**Stephen O'Donoghue - FW: Cobbora Coal - revised PPR**

**From:** Phil Towler <ptowler@emgamm.com>  
**To:** Stephen O'Donoghue <Stephen.O'Donoghue@planning.nsw.gov.au>  
**Date:** Monday, 9 September 2013 11:45  
**Subject:** FW: Cobbora Coal - revised PPR

**Cobbora Coal Project (MP 10\_0001)  
Revised Preferred Project Report (PPR)**

Figure 5.1 Predicted dewatering rates in each mining area

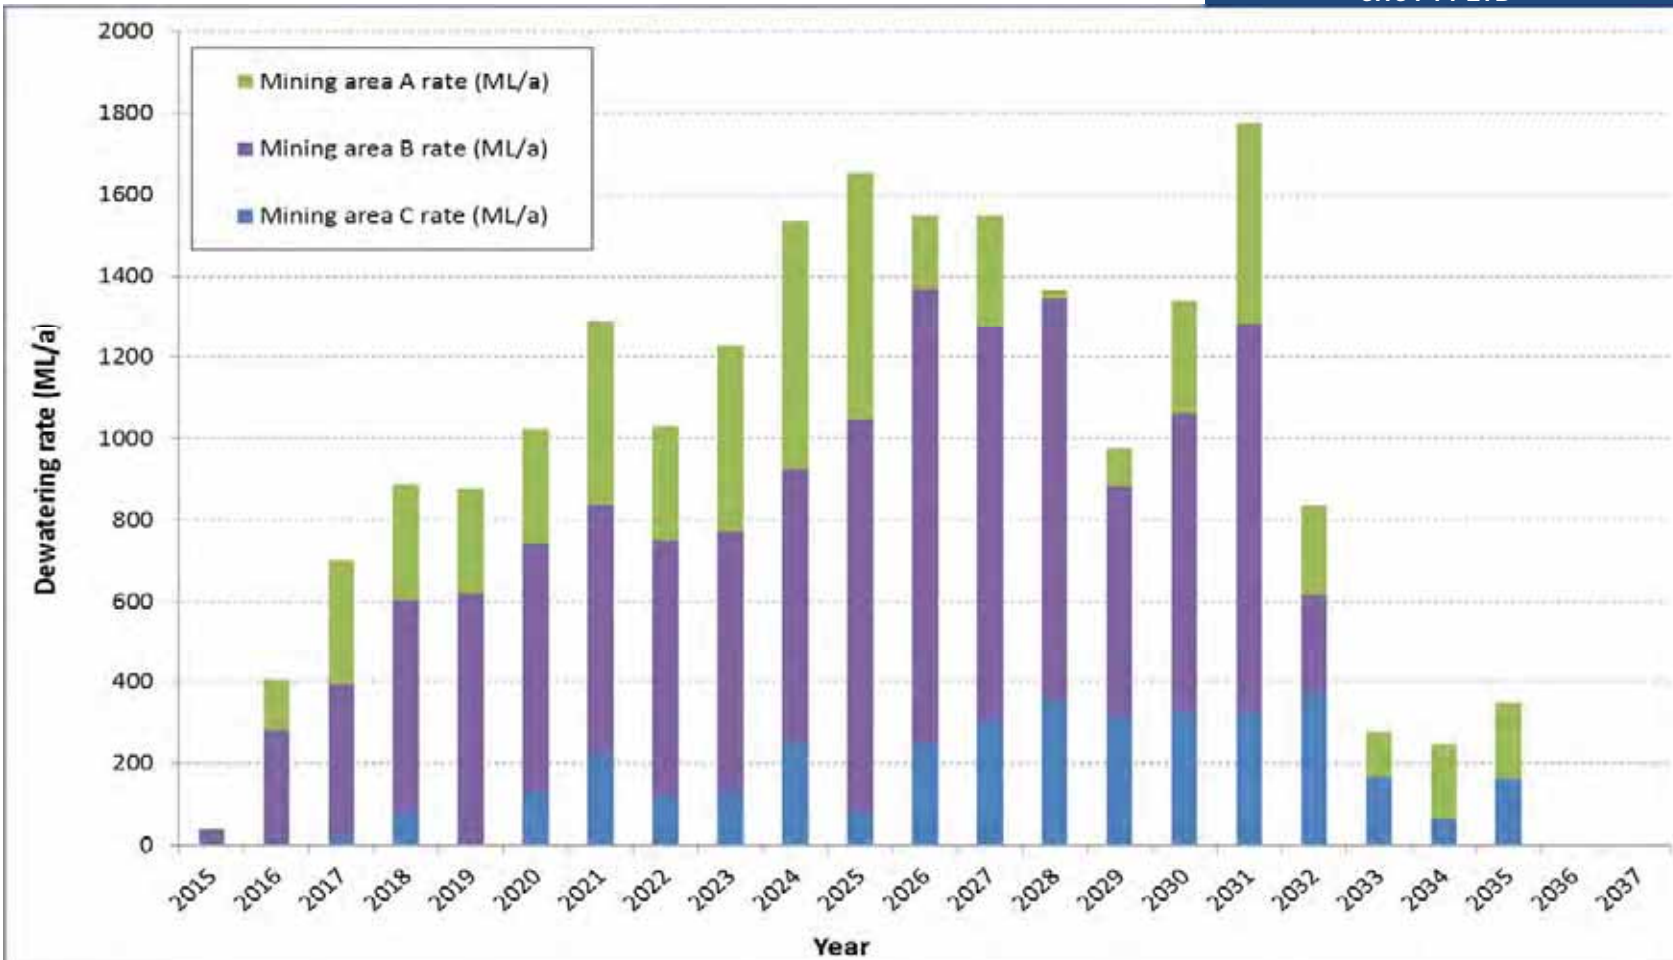
- A table detailing the revised annual groundwater inflows is requested with preference for revision of Table 6.3 presented in the Groundwater Assessment (January 2013). It is expected this may need to be explained in conjunction with operation of the proposed borefield. Confirmation of groundwater inflows into the final void post mining and at equilibrium is also requested.

A complete update of the groundwater modelling would be required to revise annual groundwater inflows. Work required to prepare inputs the model, modelling, checks, interpretation, report preparation (detailing all of the changes to support the information presented in the table) and reviews would take approximately two to three months. We believe that the groundwater assessment presented in the PPR and the confirmation results presented in the PAC Responses Report Appendix E provides sufficient information to determine if adequate management measures are proposed to minimise impacts and to determine if the groundwater impacts are acceptable in the wider project context. As noted above, the groundwater modelling will be updated based on the final detailed design as part of the groundwater management plan (operations). It is anticipated that approval conditions will require that this plan is completed prior to operations commencing.

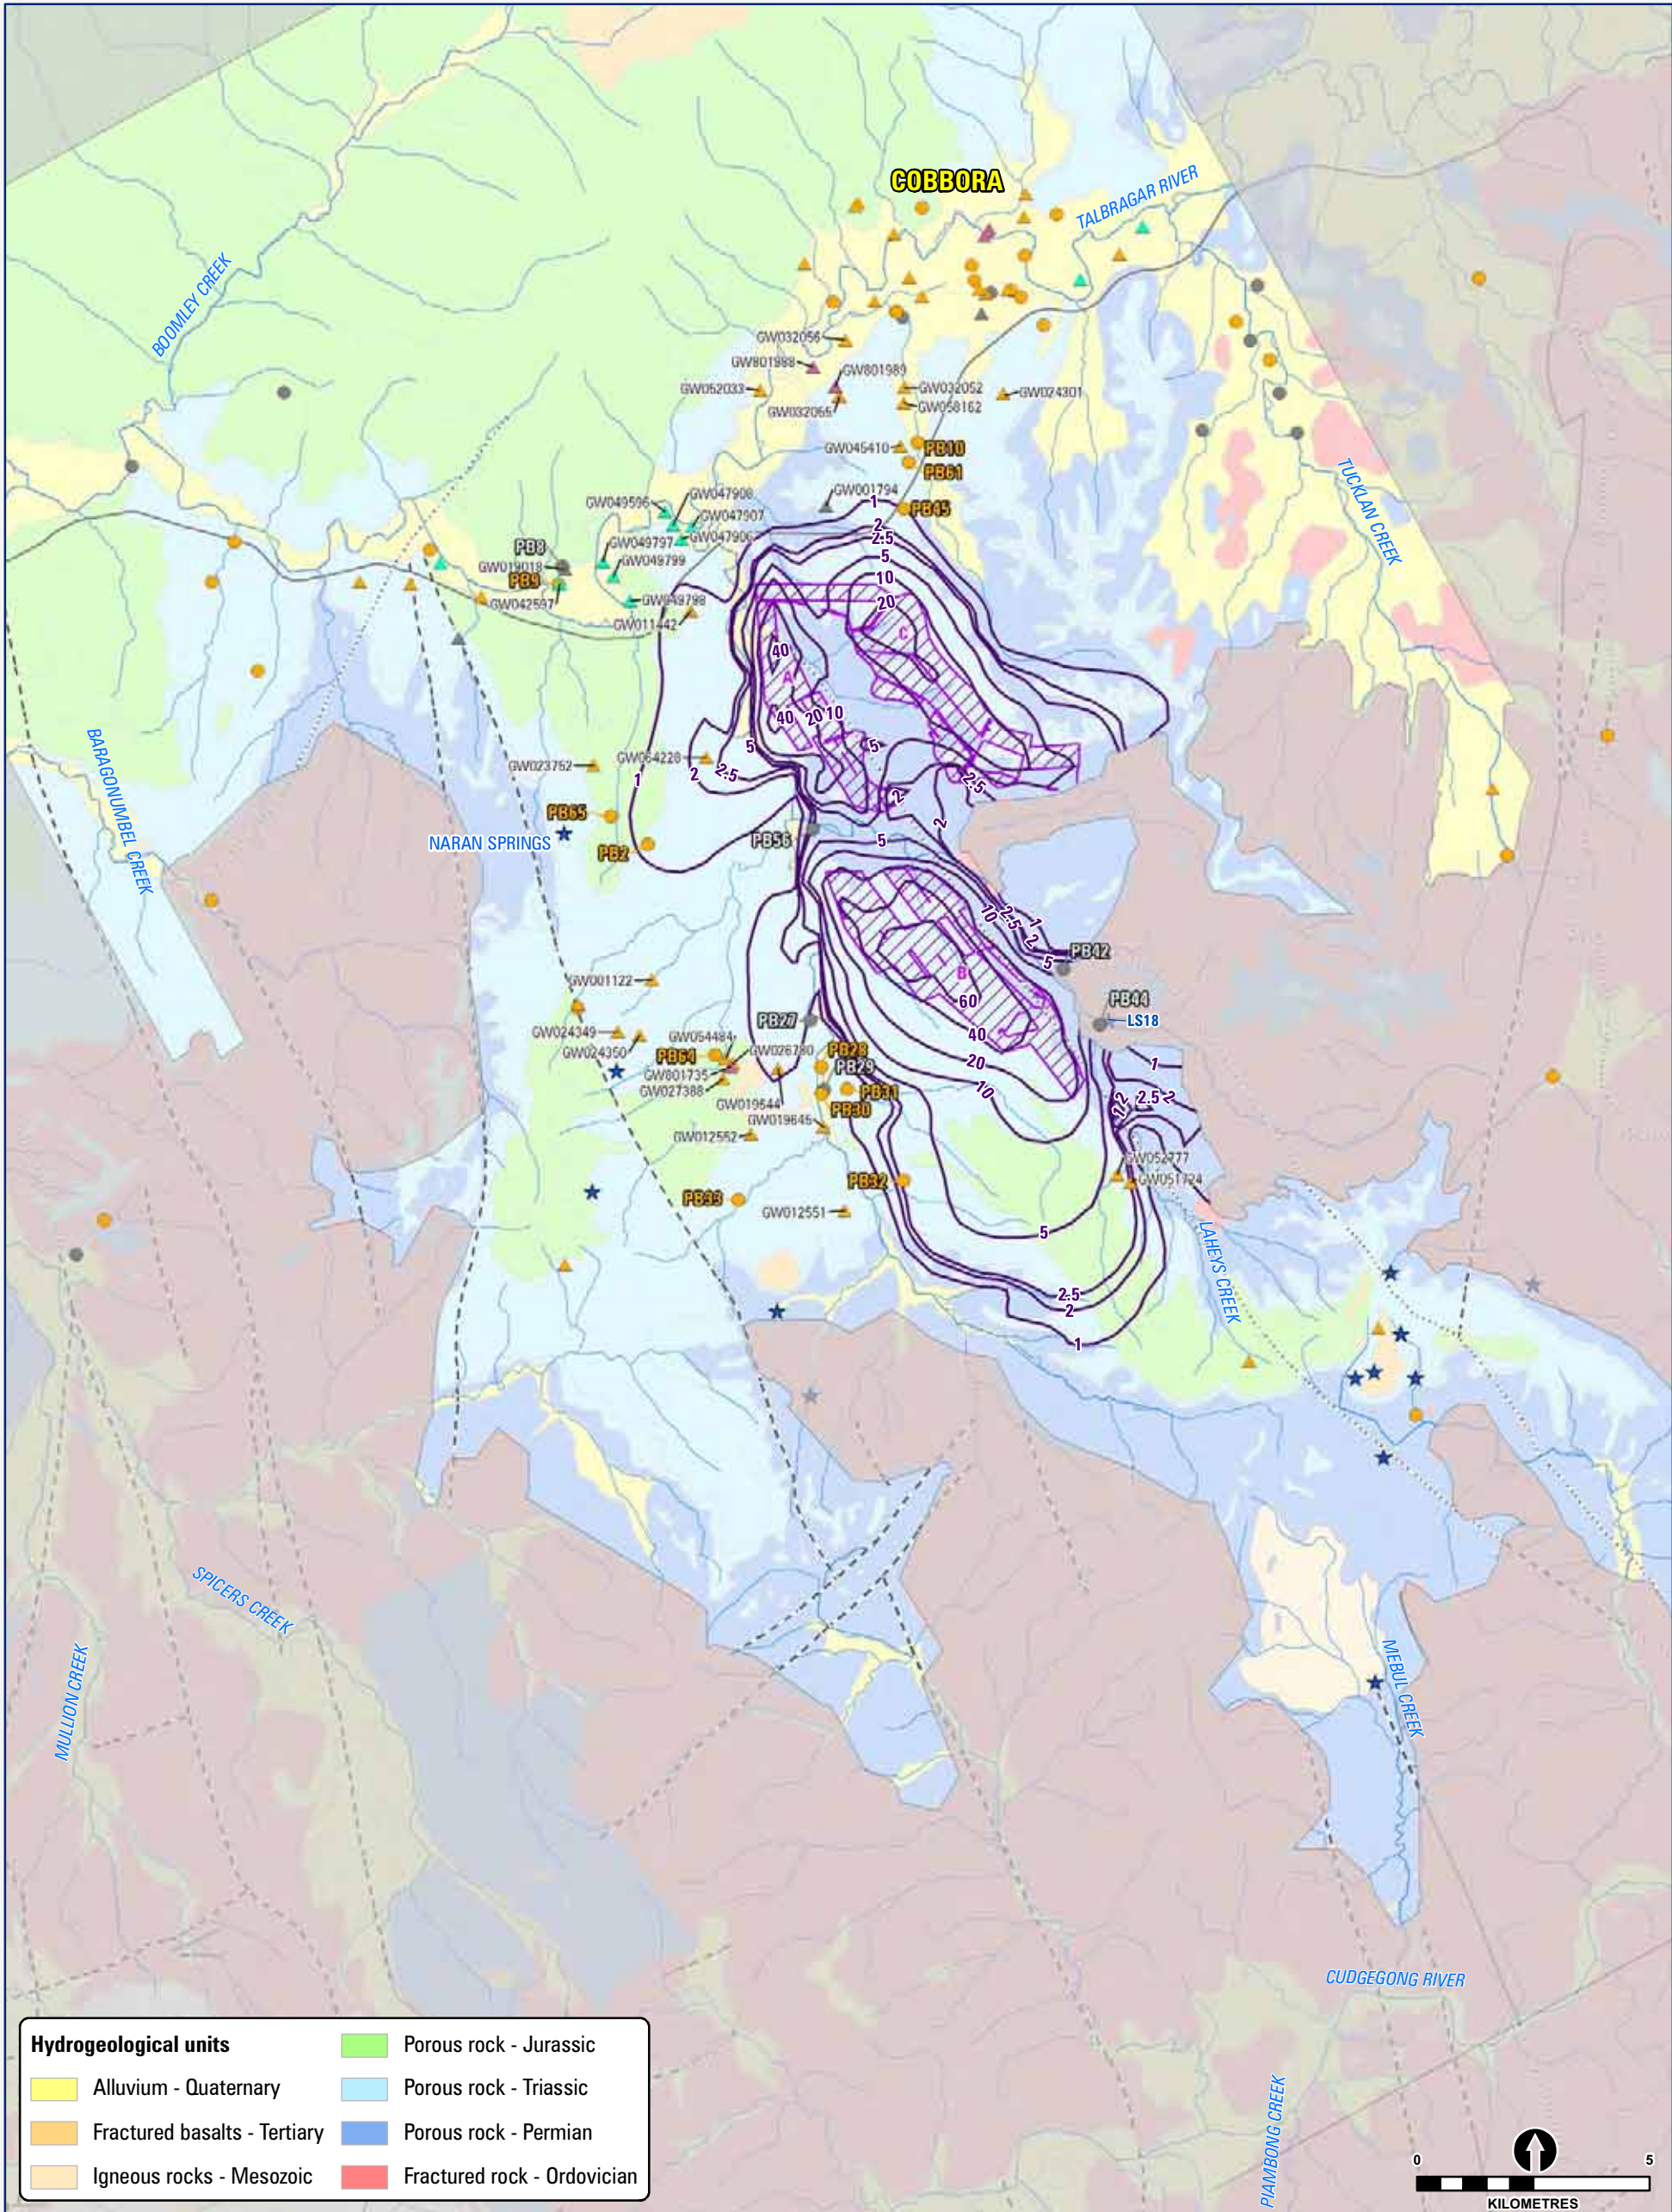
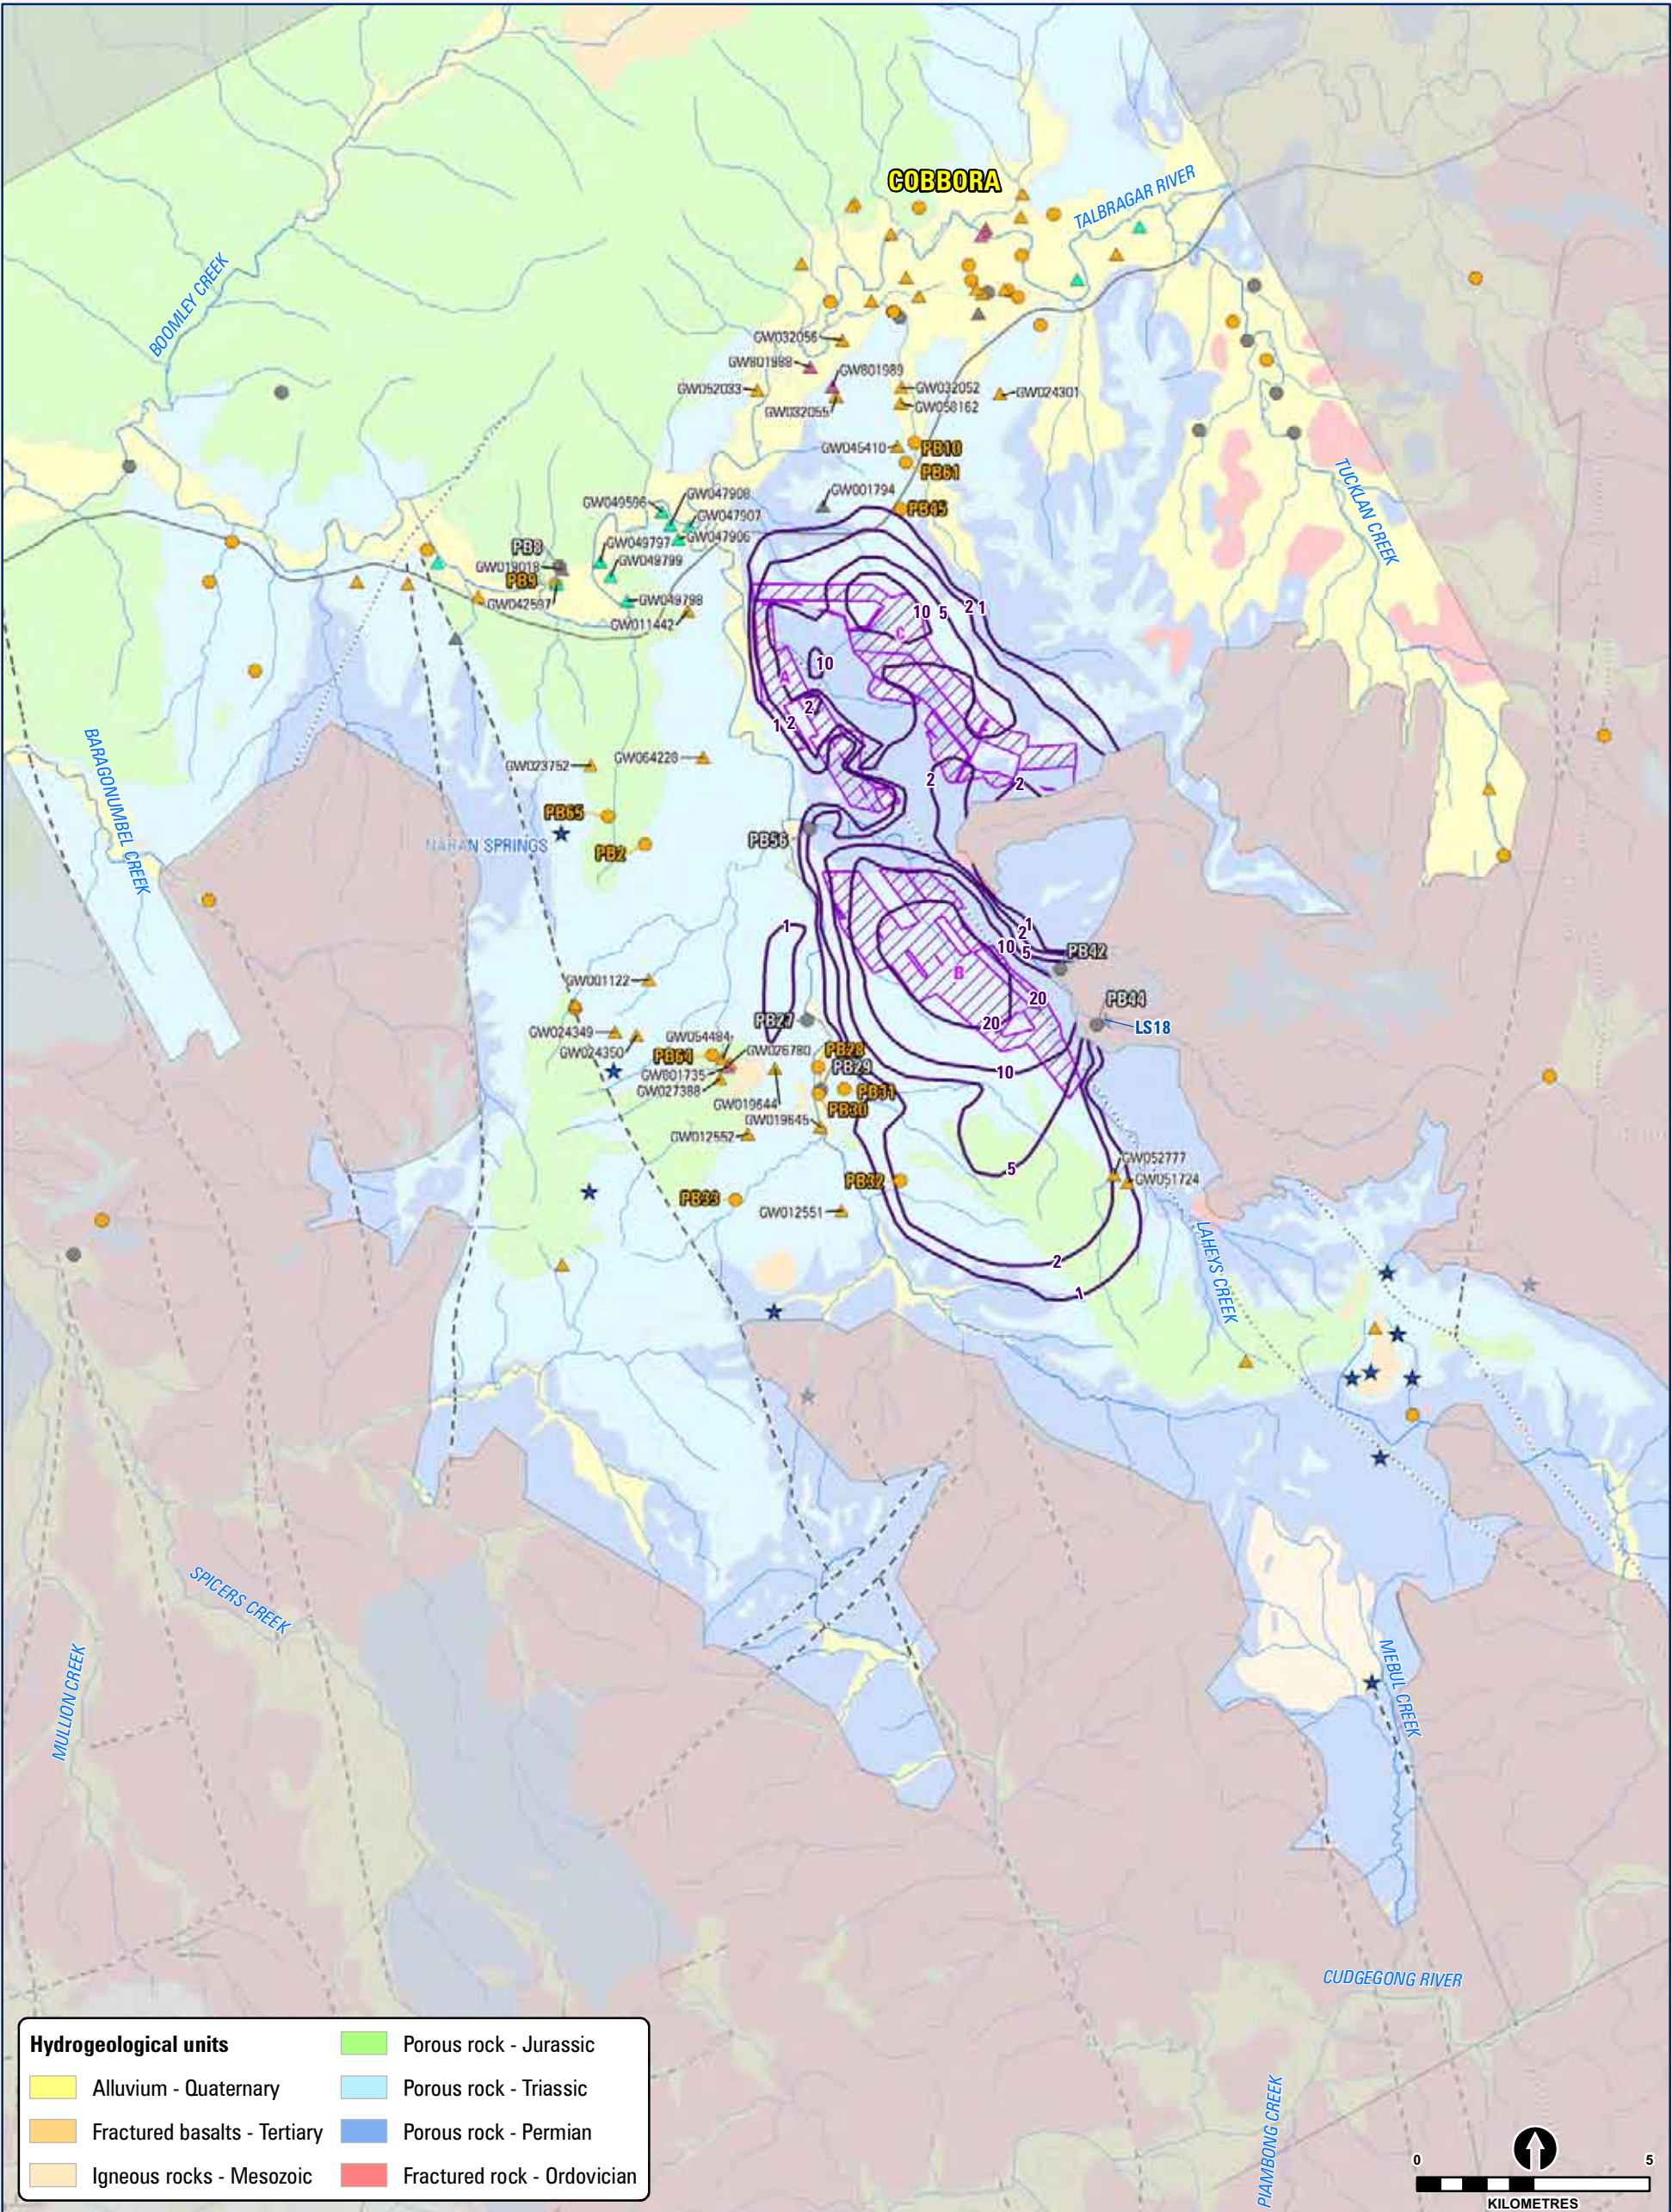
- Other changes in the revised PPR include reconfiguration of the final saline void lake dimensions and surrounding landform. The worst case scenario final water level is similar to the previous design. The reduced freeboard (to 6 metres) from this revised design still holds considerable storage before overtopping. The final void in the southern extent of mining area B remains a regional groundwater sink.

- A revised cross-sectional diagram of the final landform across mining area B is requested to illustrate the regional surface and groundwater features and revised final void geometry.

Agree.

The regional surface and groundwater features will not be changed significantly. A cross-section of mining area B is presented in Figure 3.15 of the PAC Responses Report.
